Addendum No. 2

RE: Contract # C204741

Cabarrus County (B-5808)

BRIDGES #57 AND #59 OVER IRISH BUFFALO CREEK ON US-29 AND US-601.

BRIDGE CONSTRUCTION SEQUENCE

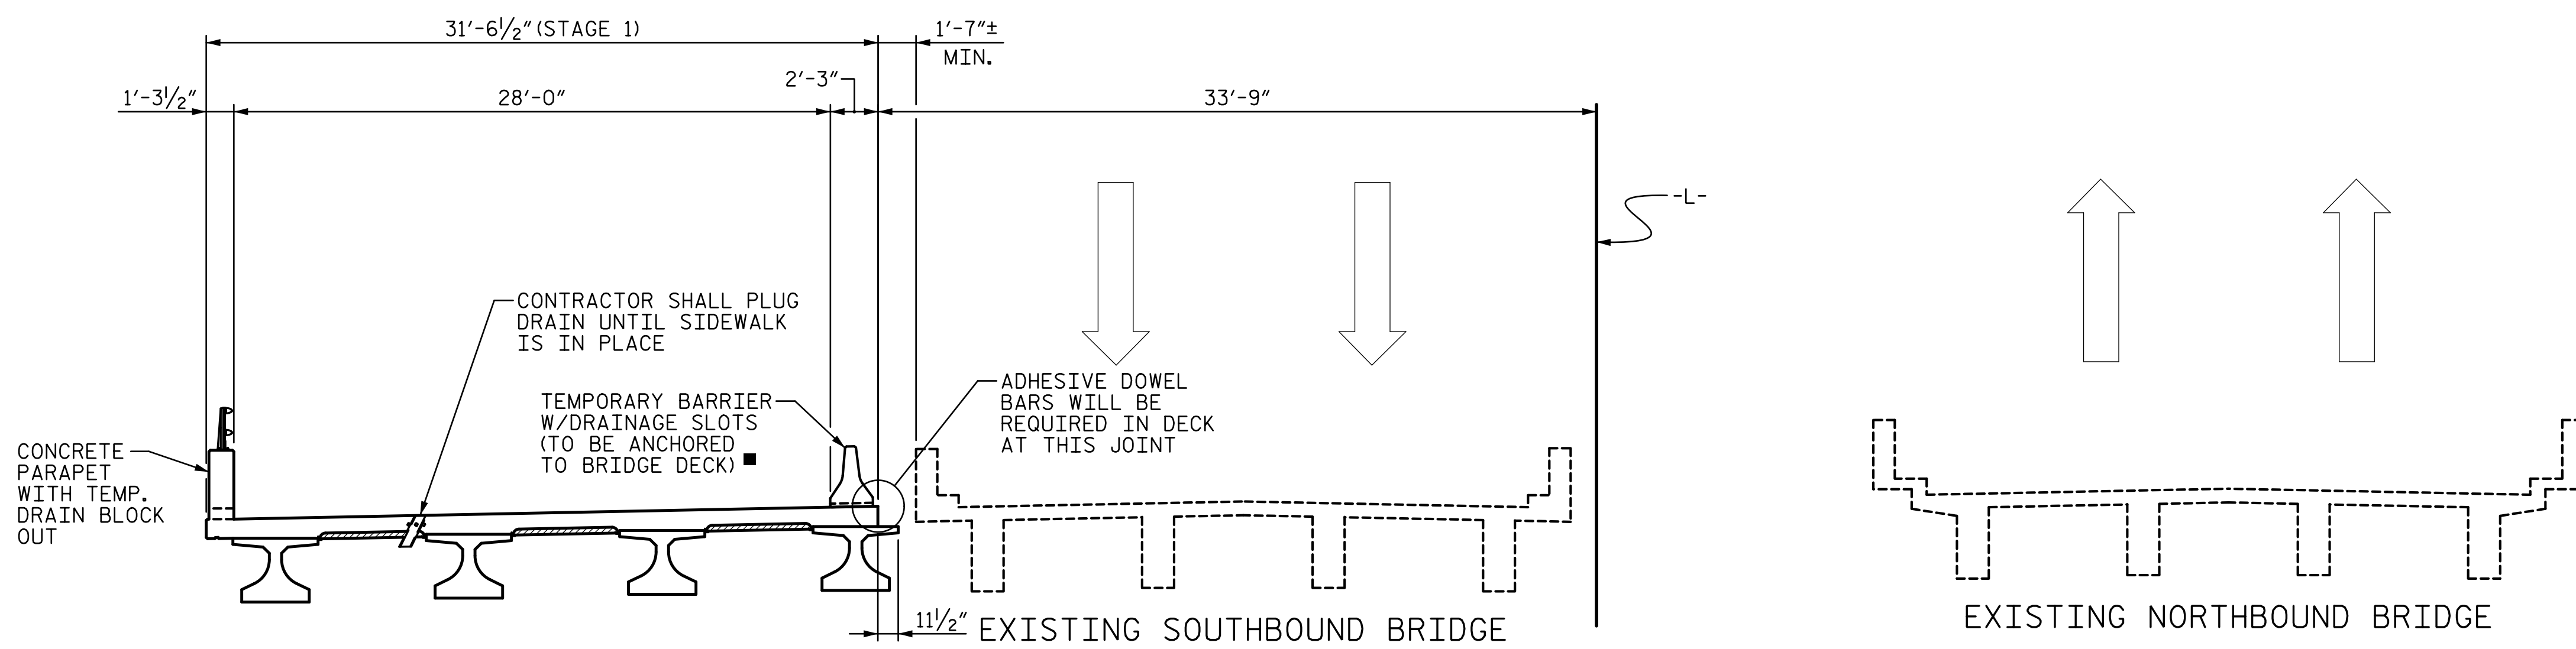
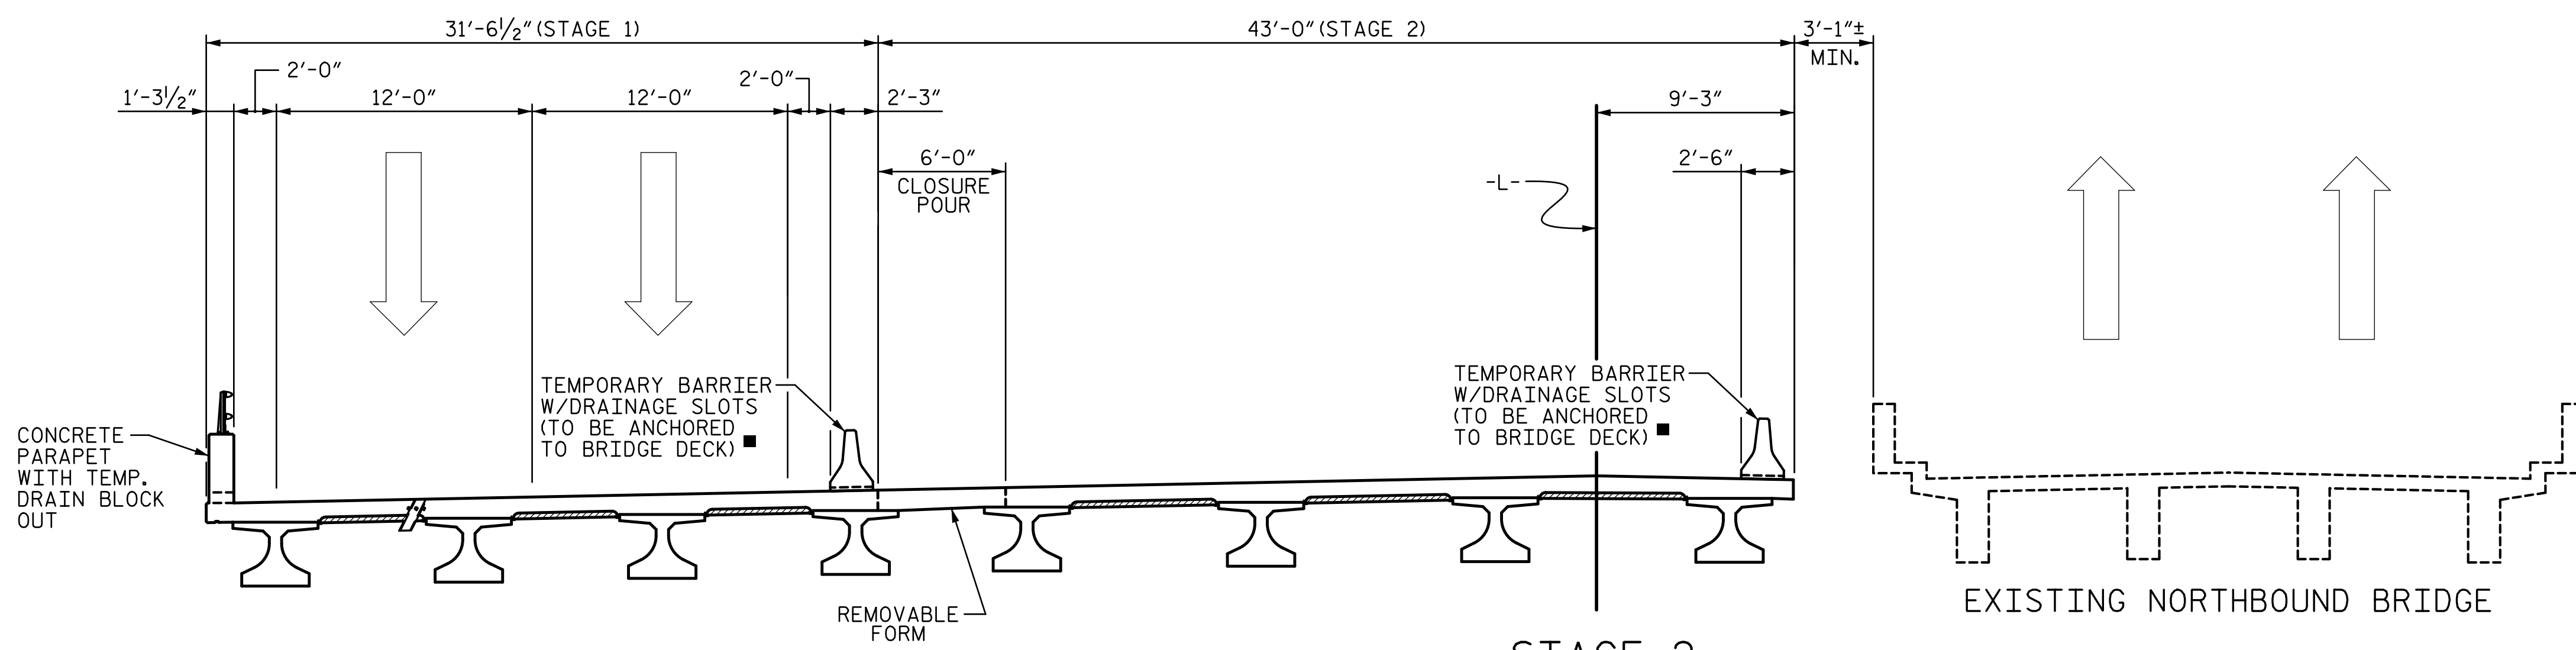
Sheet No.	Revision
S-6 thru S-8	Note regarding Temporary Barrier added.
S-9	Temporary Barrier w/Drainage Slots note revised.
S-25	Twelfth Paragraph removed under "Notes".
